Response to Planning application from Hertfordshire County Council (T and CP GDP Order 2015)

District ref: 6/2021/0321/COND
HCC ref: WH/5668/2021
HCC received: 11 February 2021
Area manager: Matthew Armstrong
Case officer: Samuel Tearle

STUDIO FOUR 37 BROADWATER ROAD WELWYN GARDEN CITY AL7 3AX

Submission of details pursuant to conditions 10 (external lighting), 11 (car parking) and 13 (pedestrian access) on planning permission (6/2018/2387/MAJ)

**Figure 2A Car Park Layout**

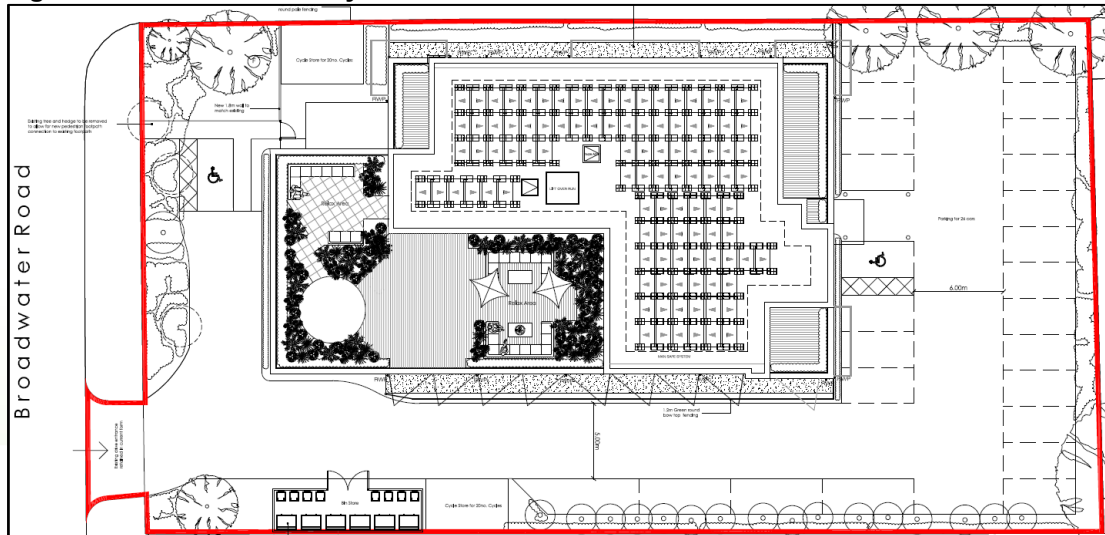
To support the discharge of Condition 11 the applicant has submitted a Car Park Management Plan (CPMP) dated Jan 2021. The perpendicular car parking spaces are shown to be accessed by a 6m width corridor, which is inline with standards. The two disabled spaces are shown to be near the entrances of the building and therefore considered suitable.

The CPMP states 24 standard bays and two accessible bays for blue badge holders are to be provided.

It is also noted two covered cycle stores for up to 20 cycles each (40 spaces in total) on the north and south of the site. The Highway Authority request that the cycle stores are secure and well-lit.

PEDESTRIAN ACCESS DETAILS
& EXTERNAL WORKS

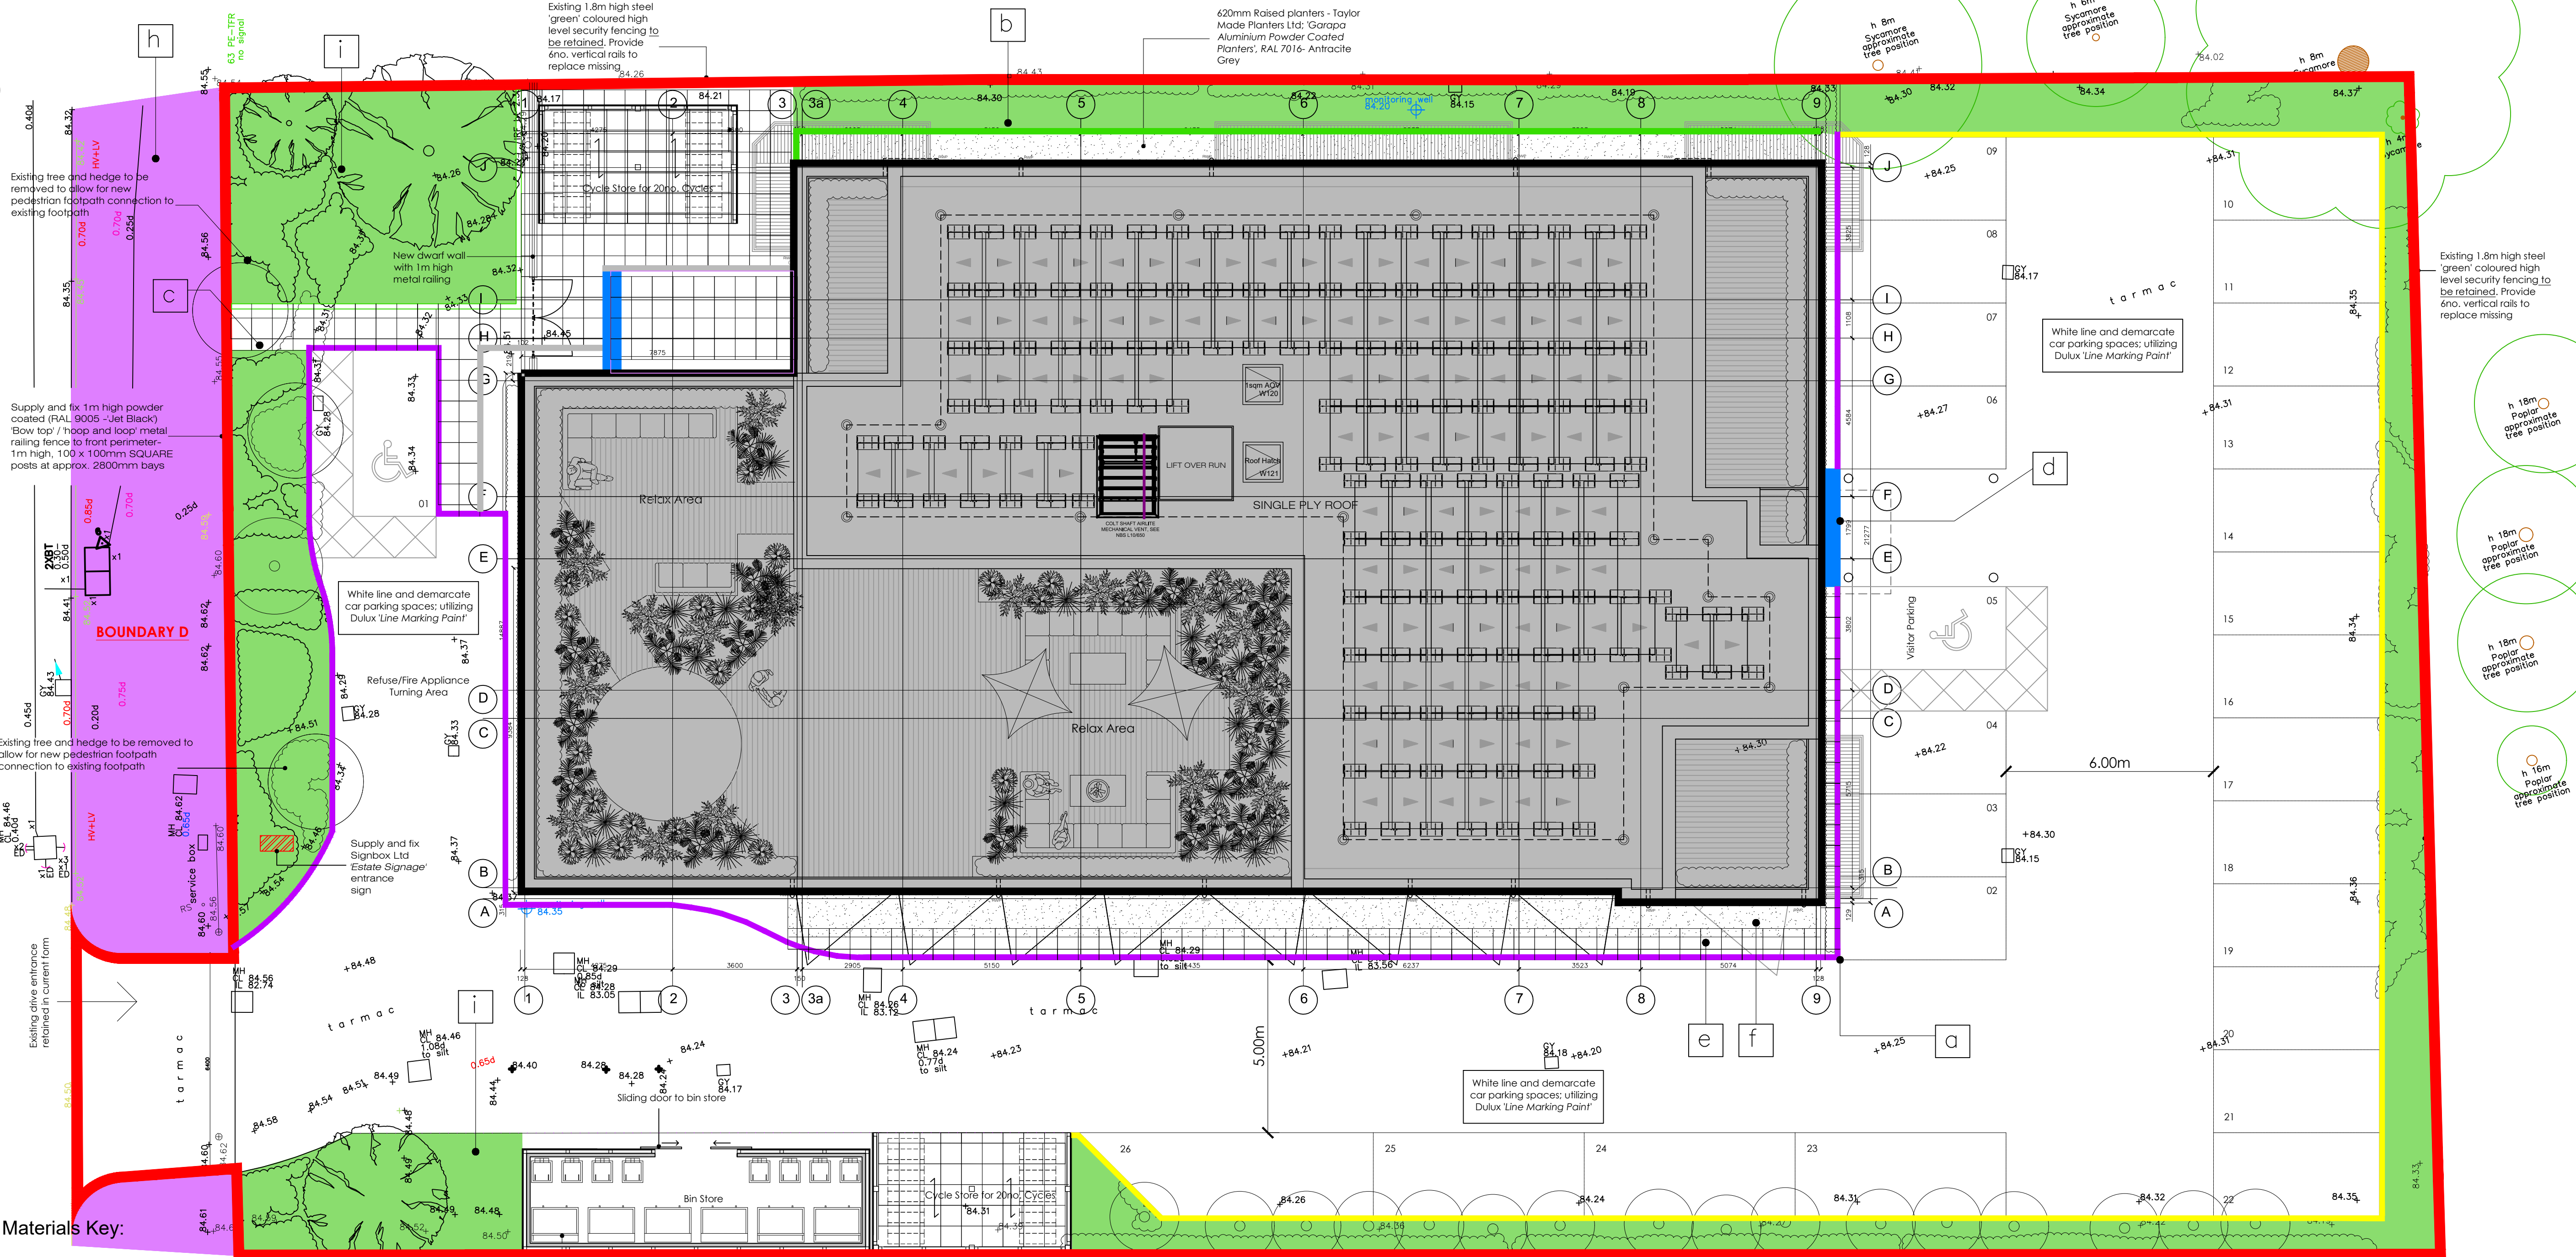
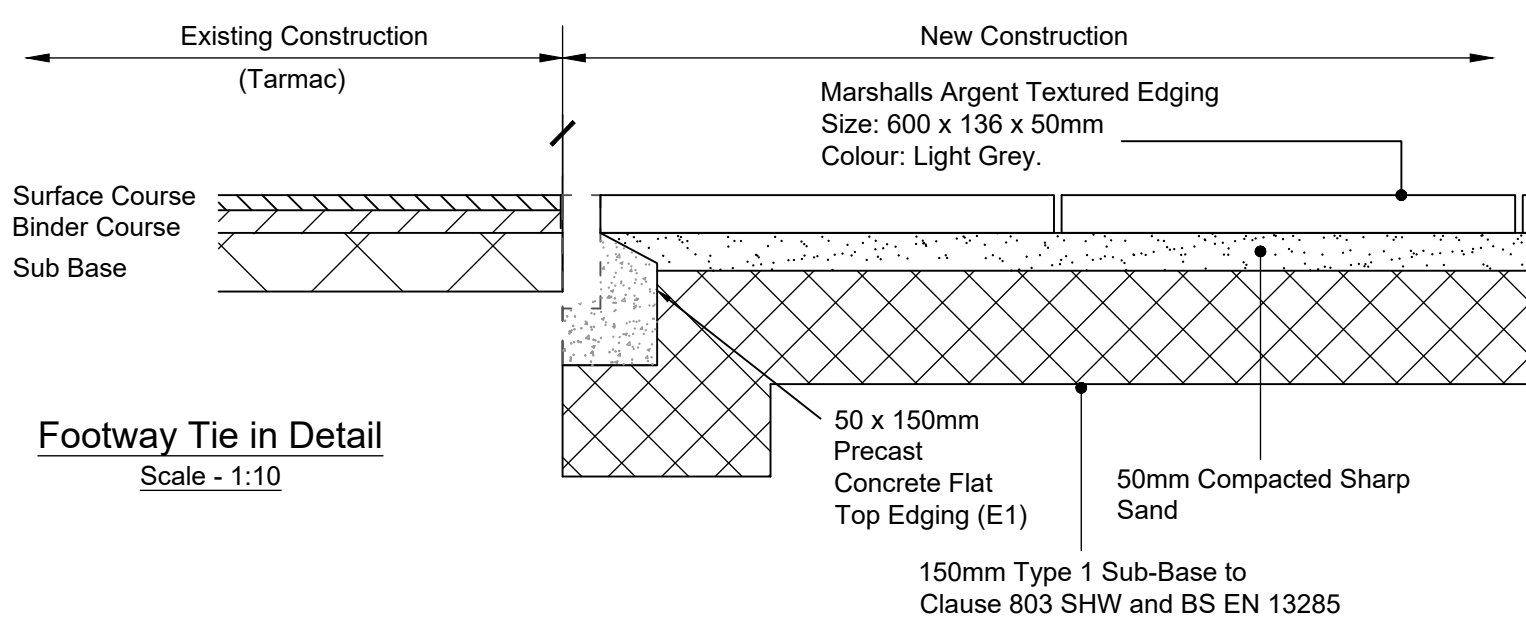
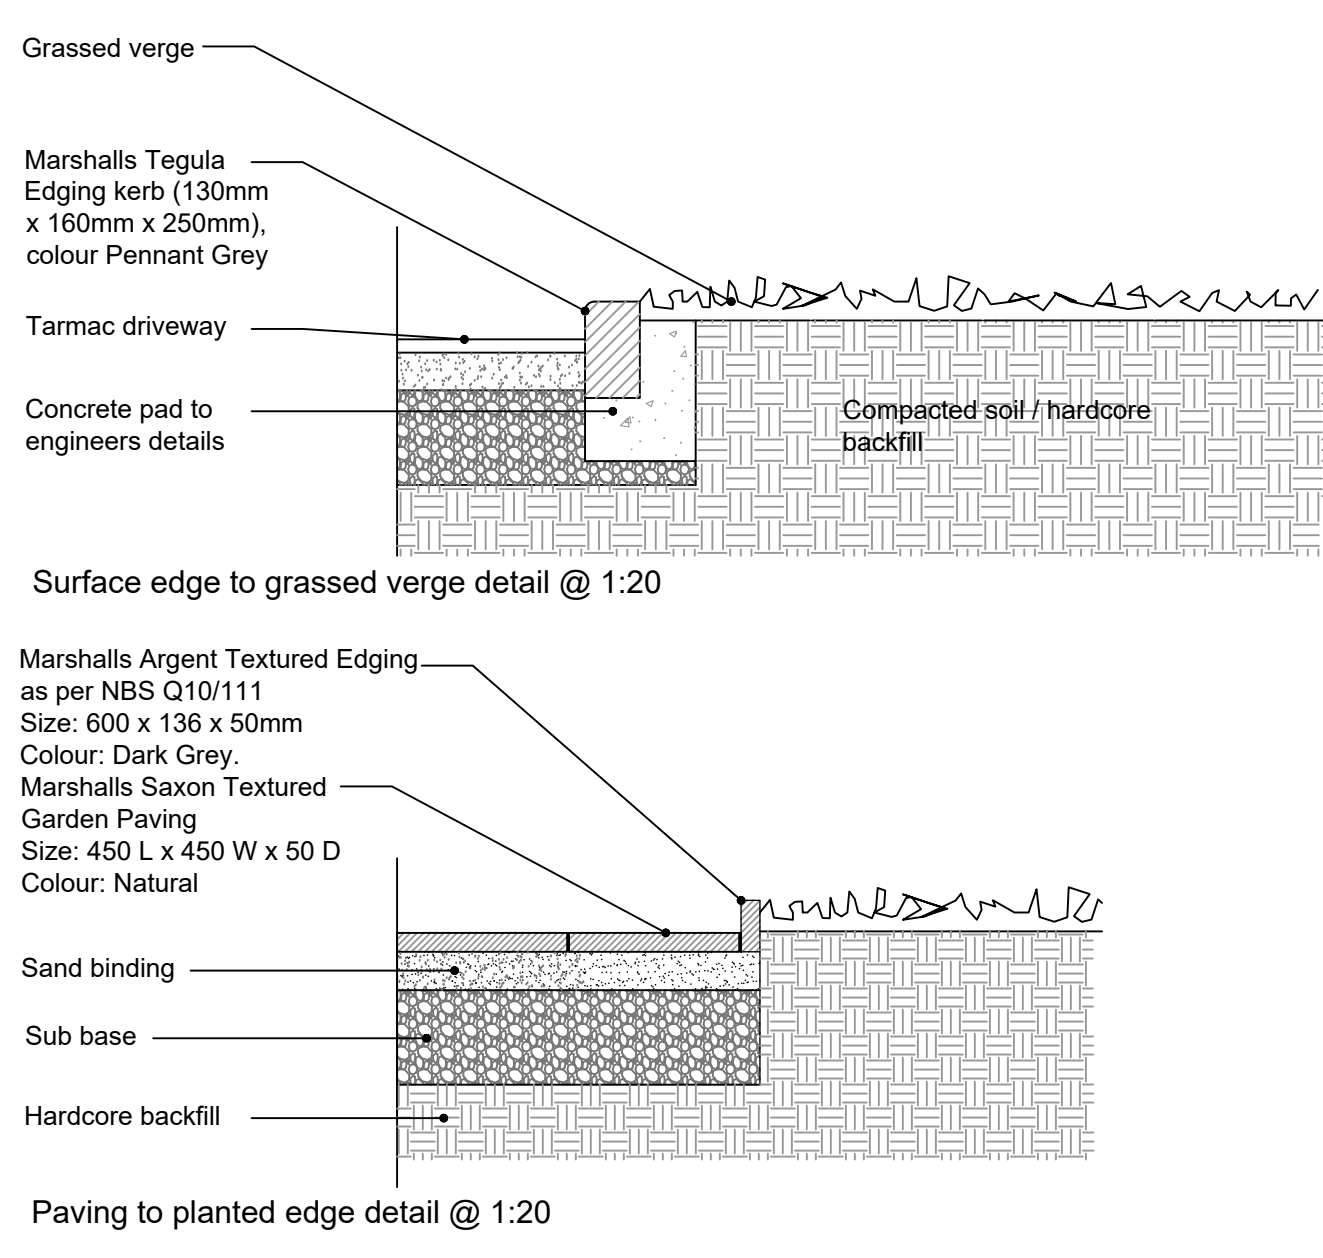
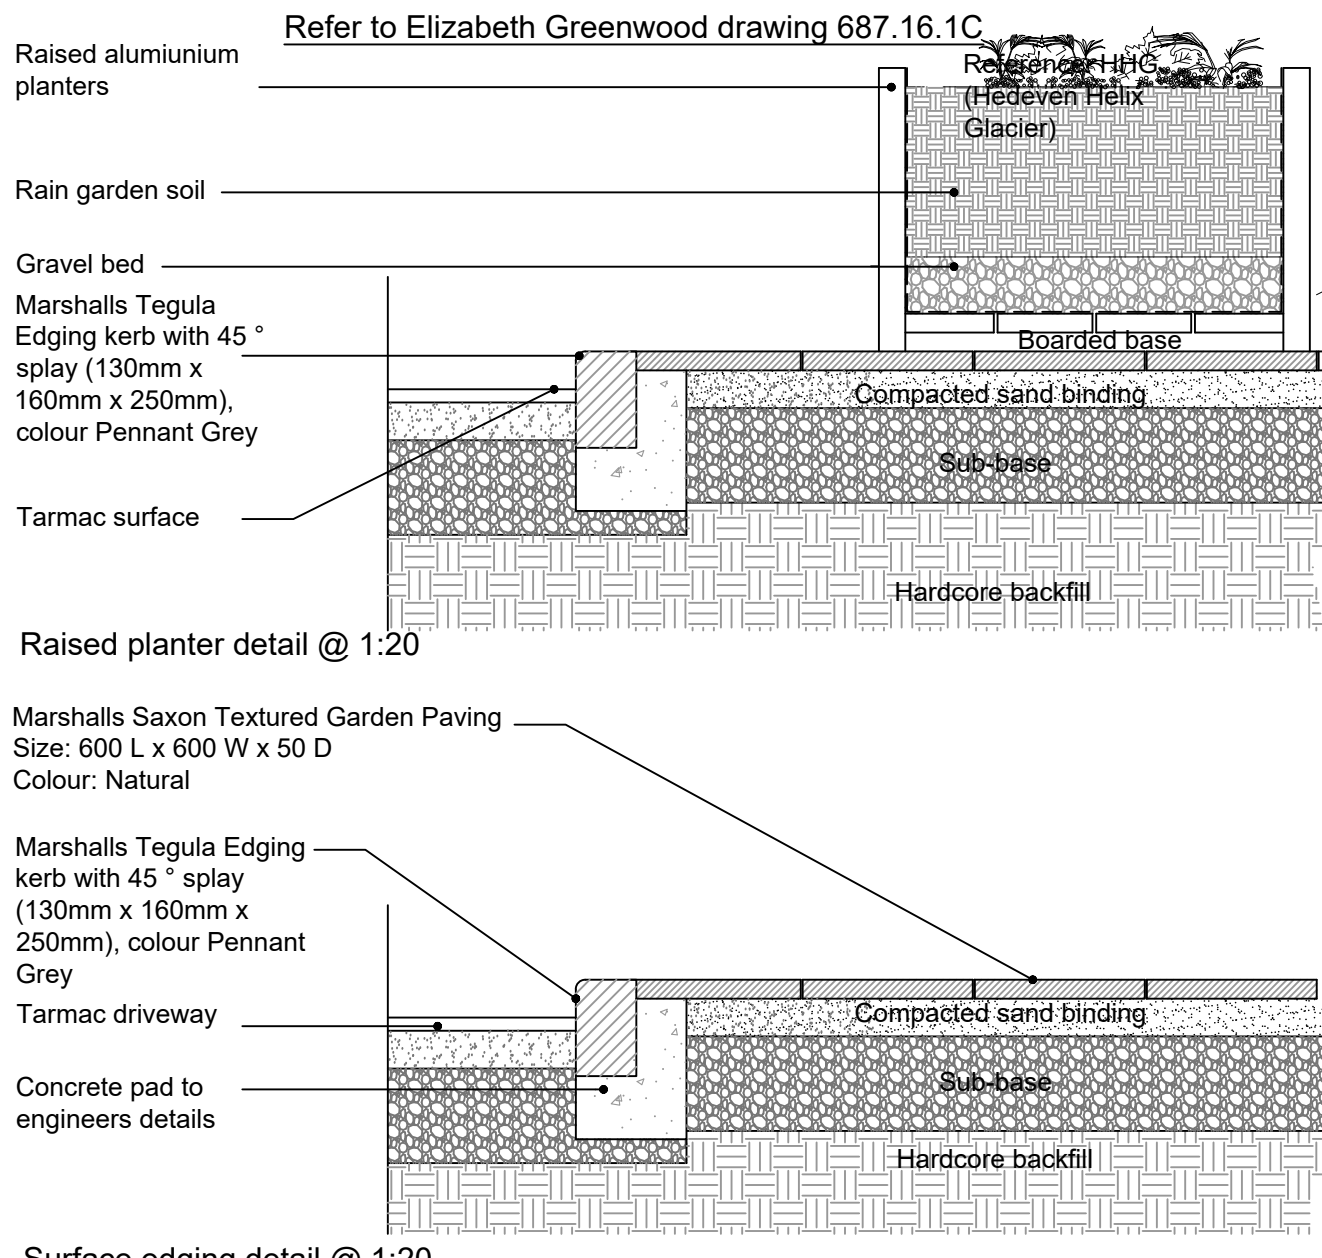
To support the discharge of Condition 13, the applicant has issued Drawing No. 250 'Pedestrian Access Details and External Works'. The Highway Authority are satisfied with the details.
